PROJECT: ROCKY TOP MOTEL & CAMPGROUND
PART NW1/4 SECTION 9, T.13S., R.68W., 6TH P.M.
EL PASO COUNTY

SHT. NAME: **DEVELOPMENT PLAN**
SHT. NO.: 1 OF 1
County File No.: PPR2140
Prepared by the office of:
Oliver E. Watts, Consulting Engineer, Inc.
614 Elkton Drive
Colorado Springs, CO 80907
(719) 593-0173
Oliewatts@aol.com
Celebrating 43 years in Business

Site Development Plan_V3.pdf Markup Summary

SITE PLAN

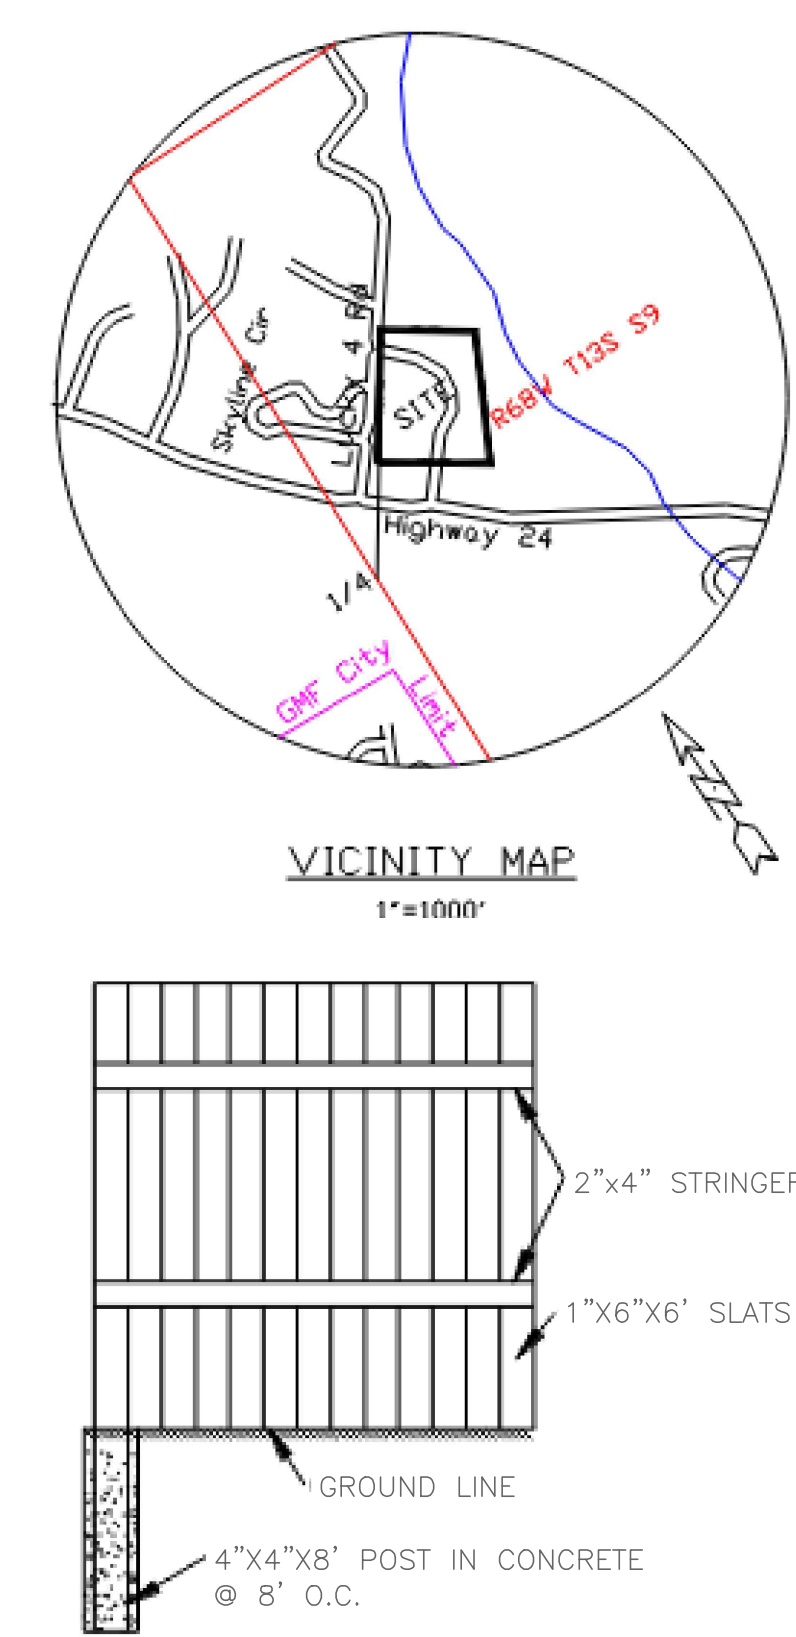
Please provide graphical depiction of opaque fence to be used as screening.

This symbol is missing in the legend. Please identify.

Please show all proposed and existing lights on site plan.
